Our ref: Project Pluto Data Centre (SSD-69223466)

26 August 2025

Subject: Request for Additional Information

I refer to the Submissions Report for the Project Pluto Data Centre (SSD-69223466) at 132 McCredie Road, Guildford West, within the Cumberland local government area.

Appendix B. Vehicle Swept Paths

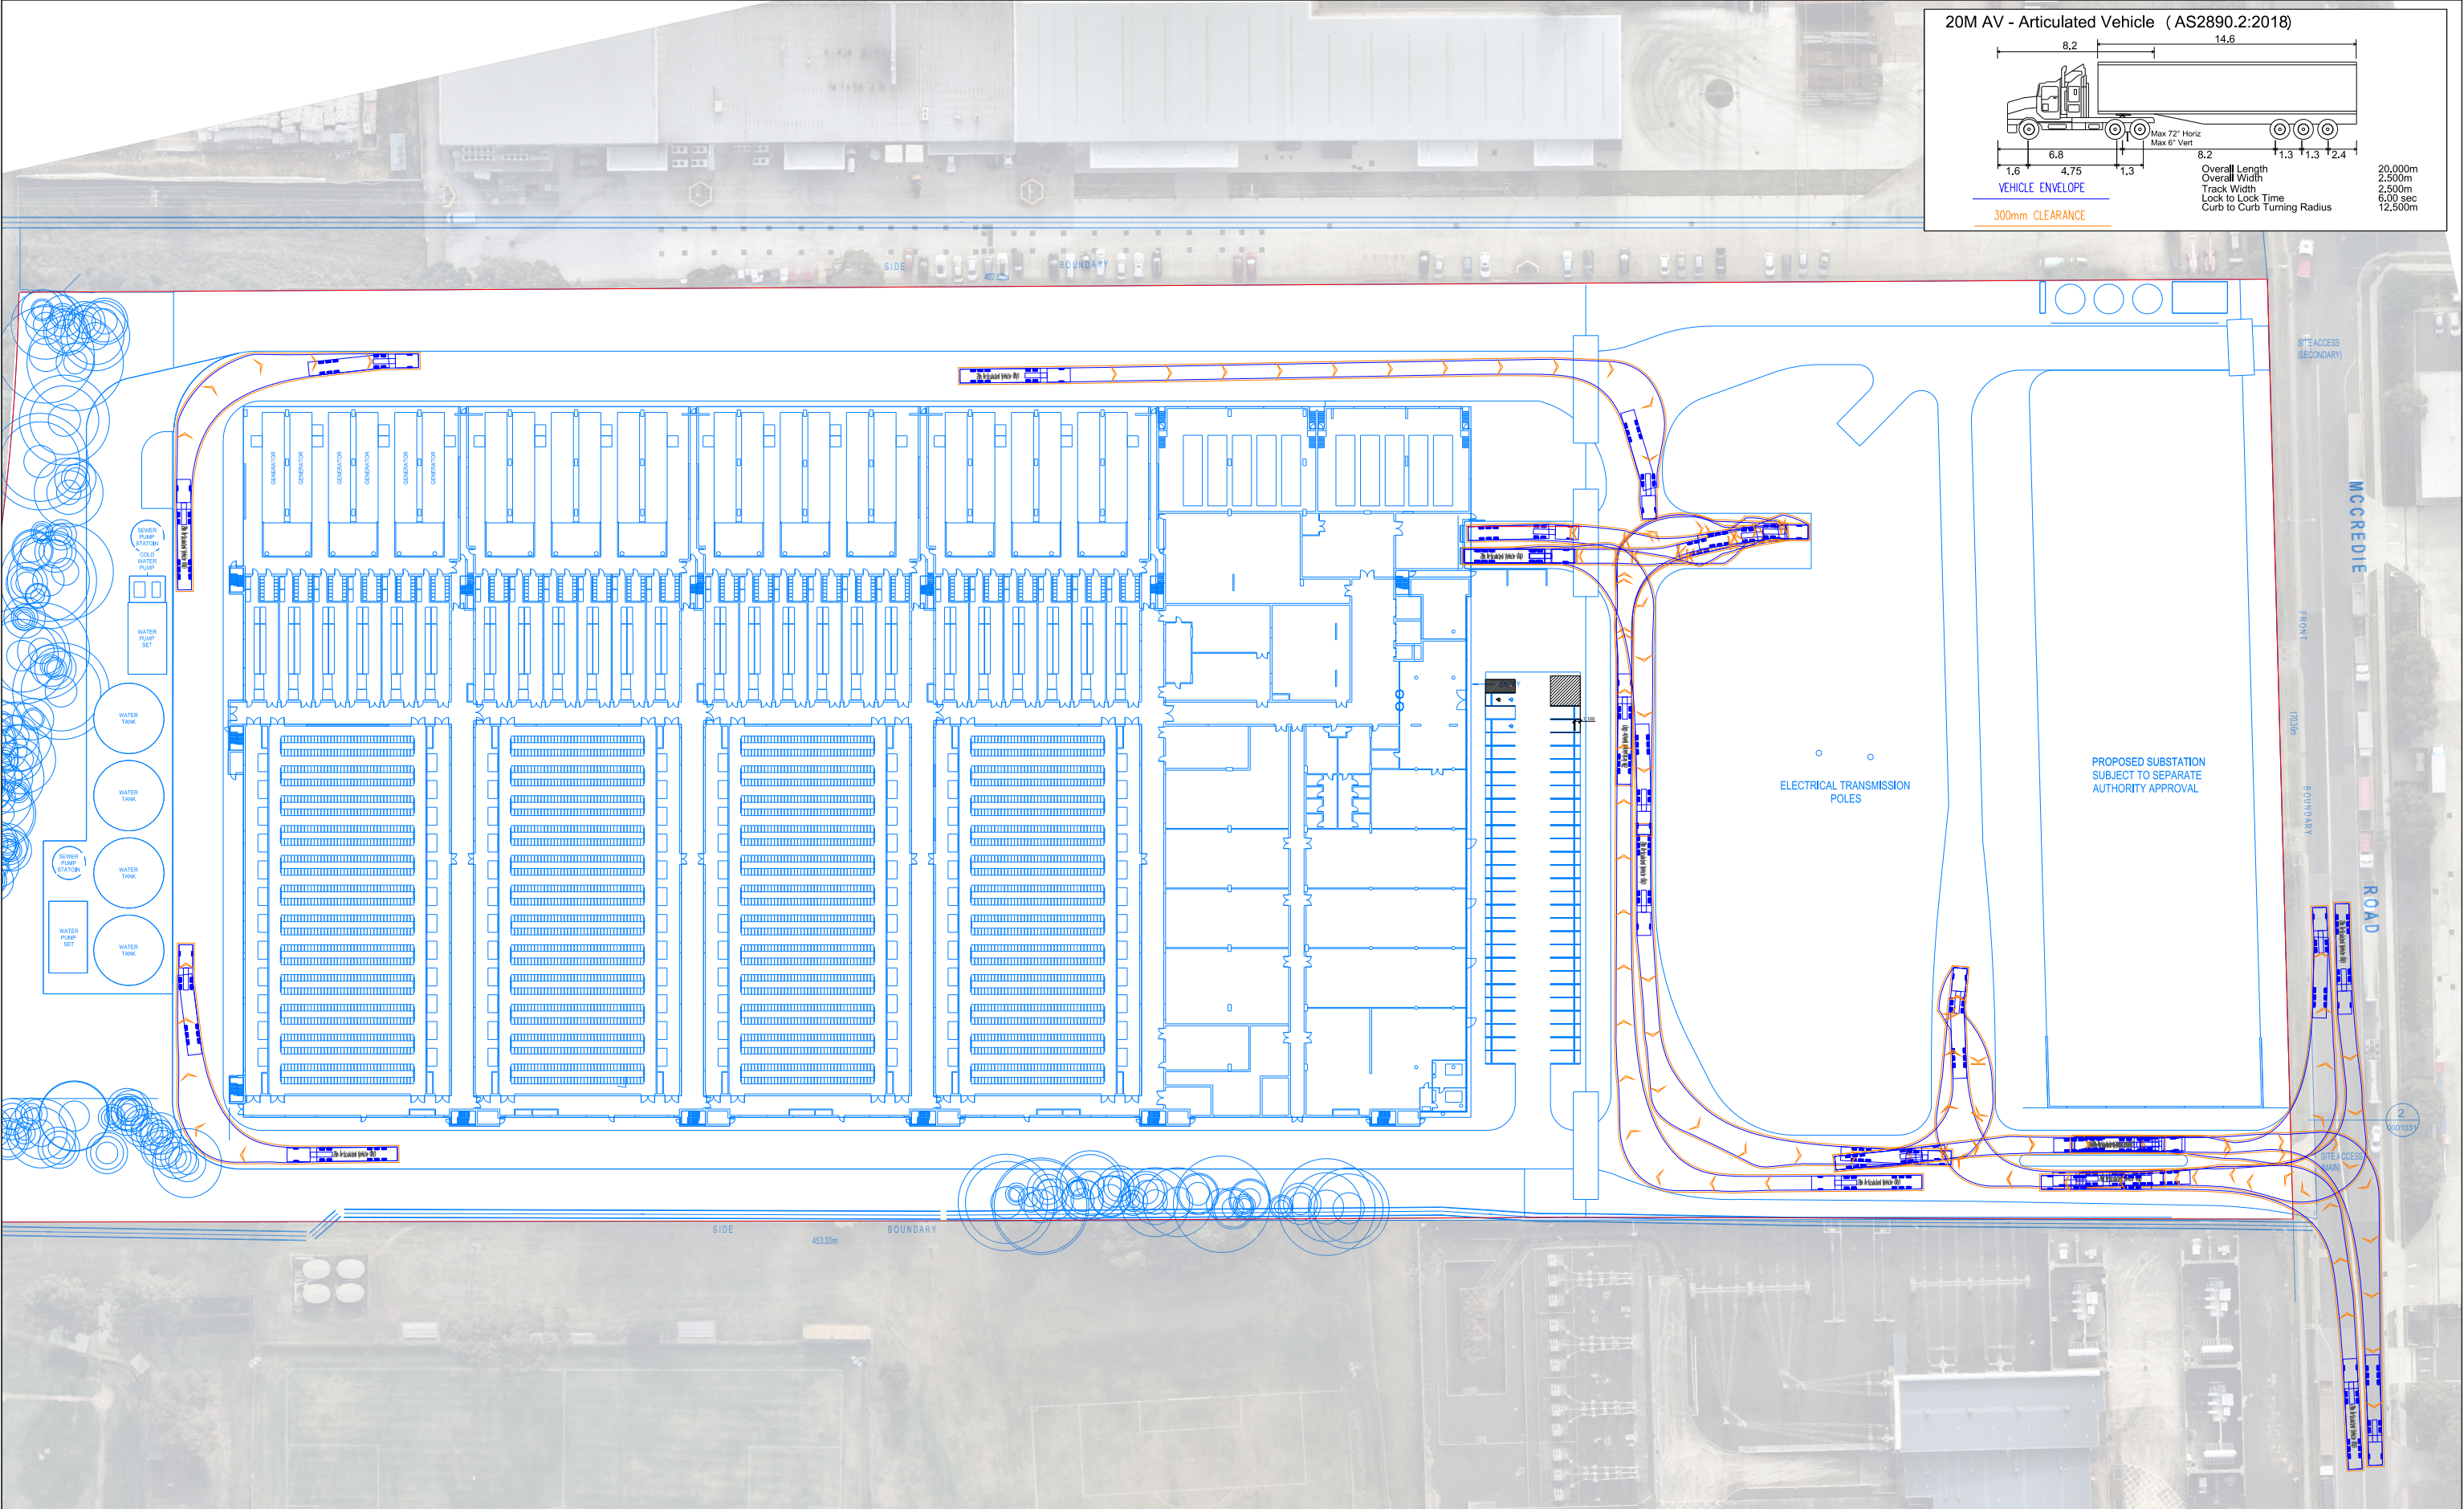
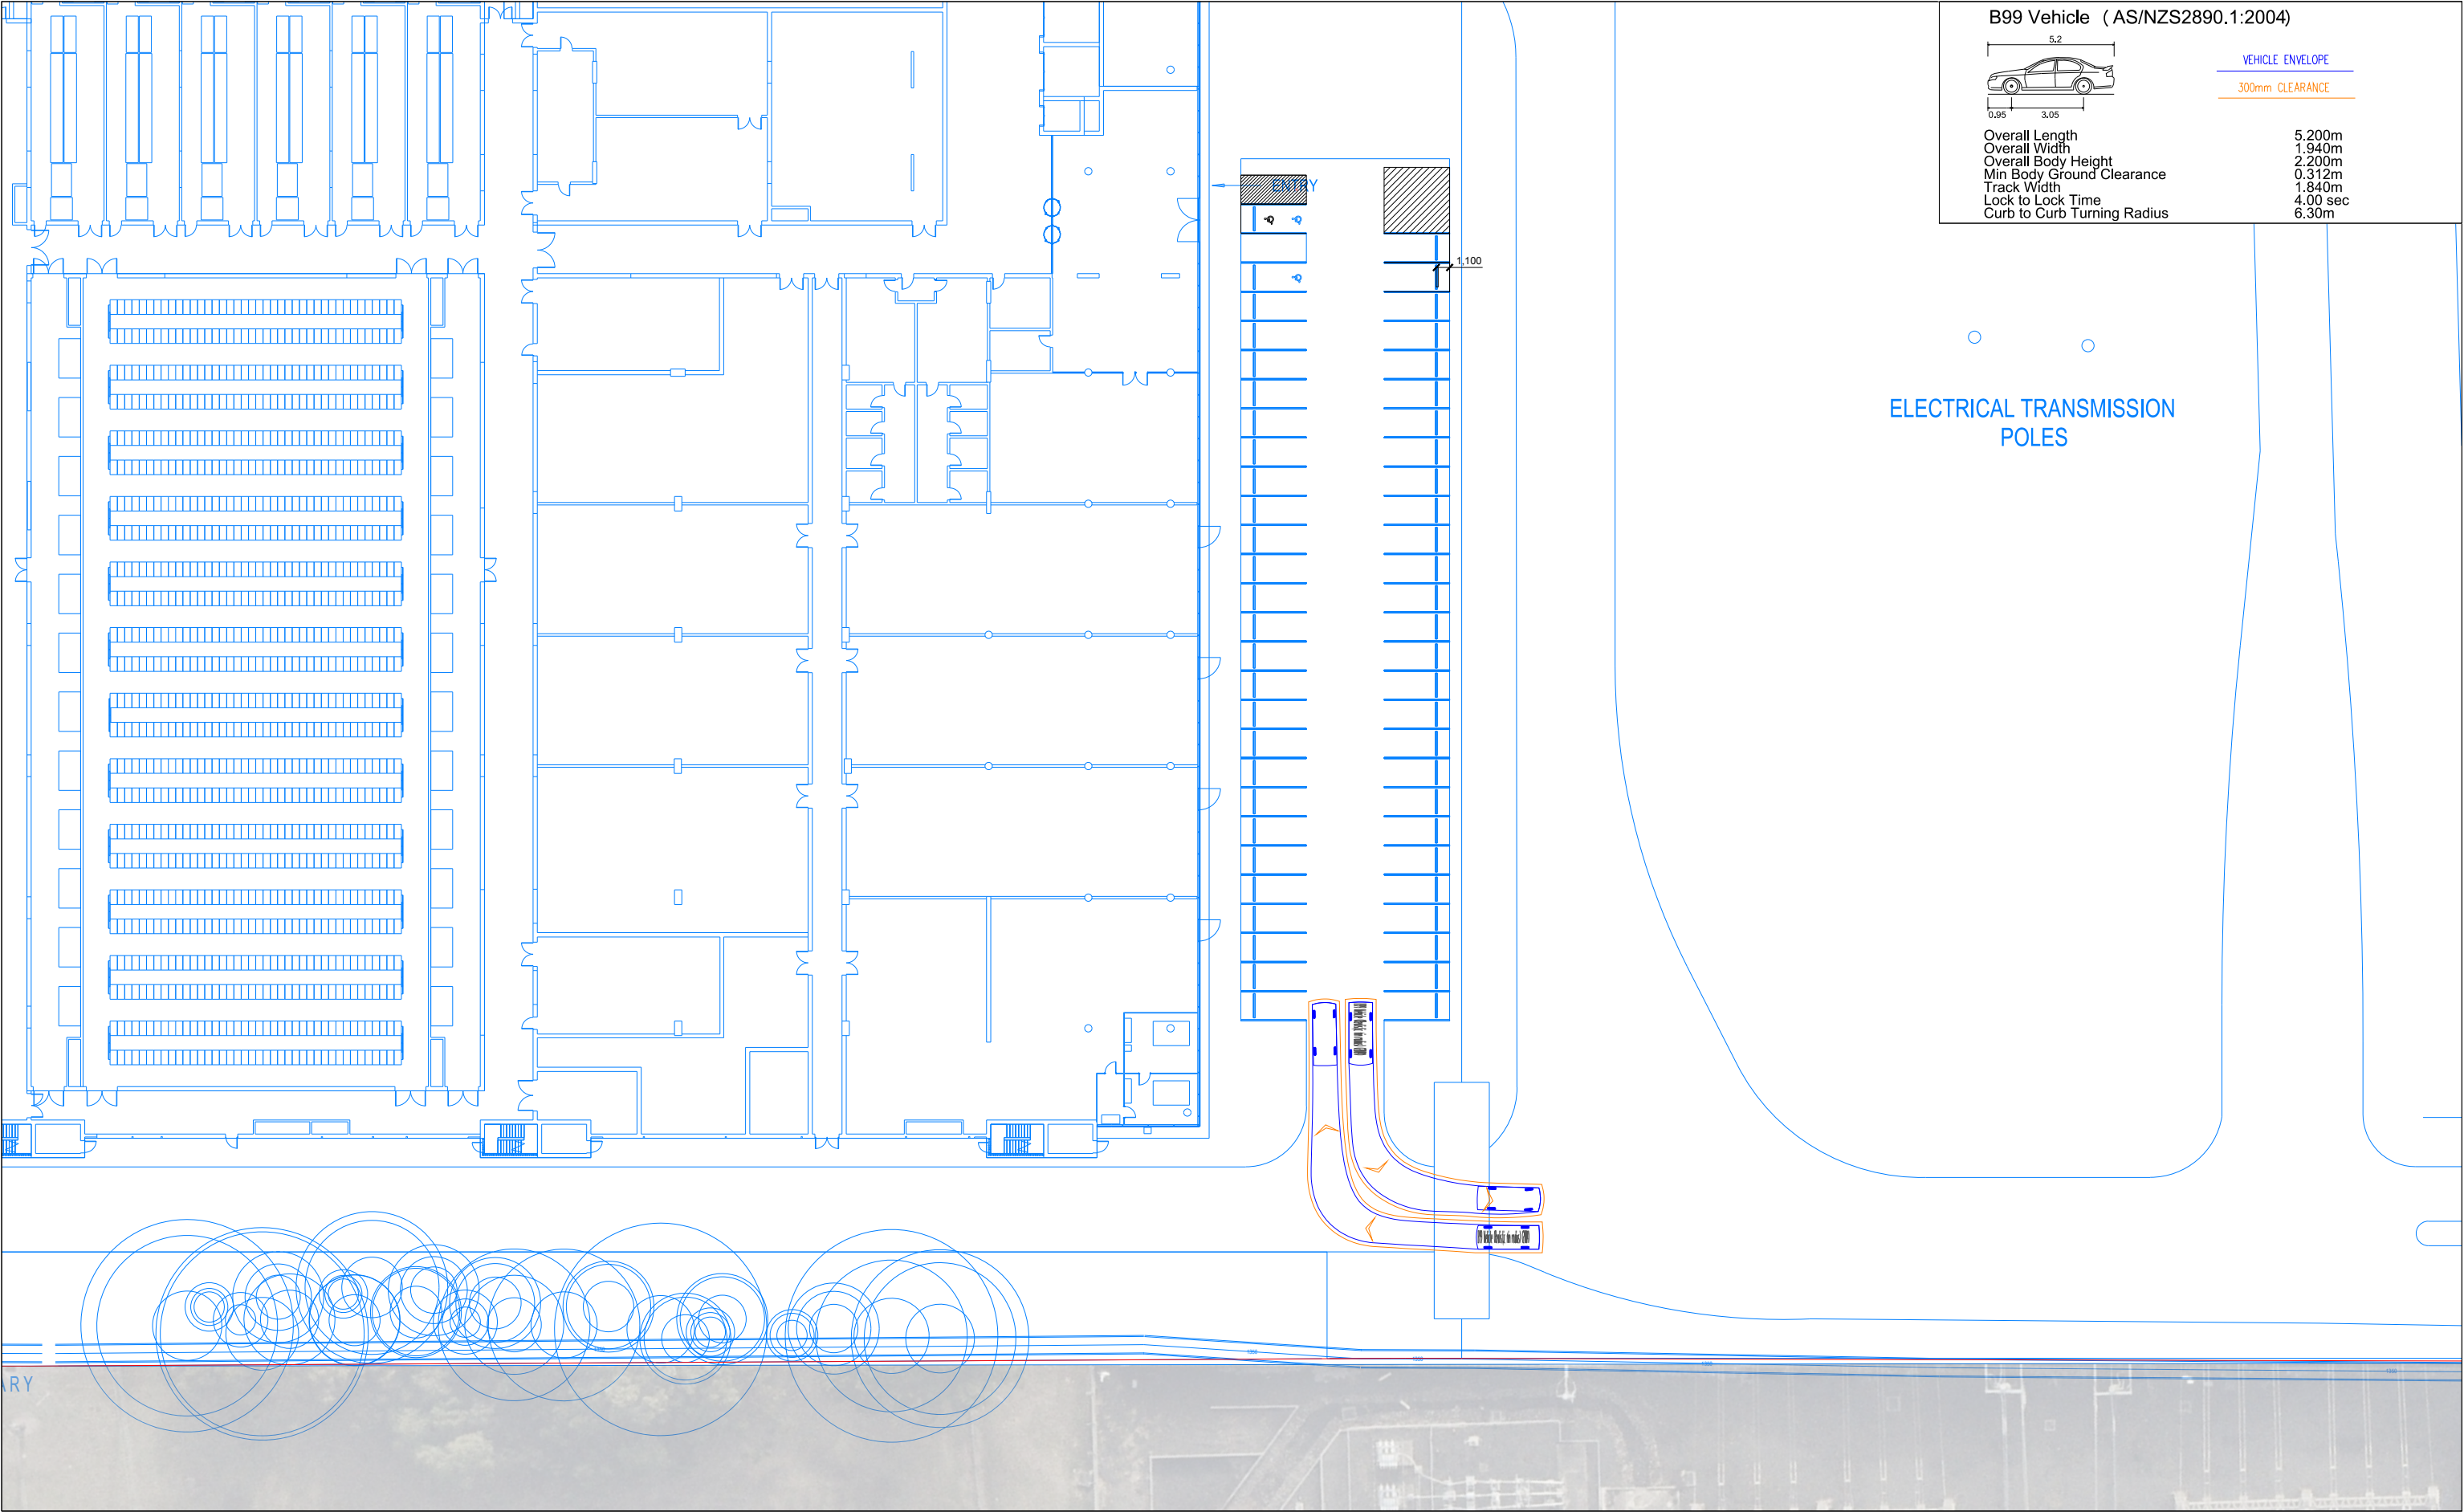
2. The Department's previous concerns regarding the movement of heavy vehicles in and out of the site has not been adequately addressed. The provided SWEPT path analysis diagrams appear to continue to demonstrate that heavy vehicles cannot enter and exit the uninhibited. The proposed site access arrangements should be updated to accommodate the anticipated largest vehicles to access the site or be restricted from access and smaller vehicles considered for site operations.
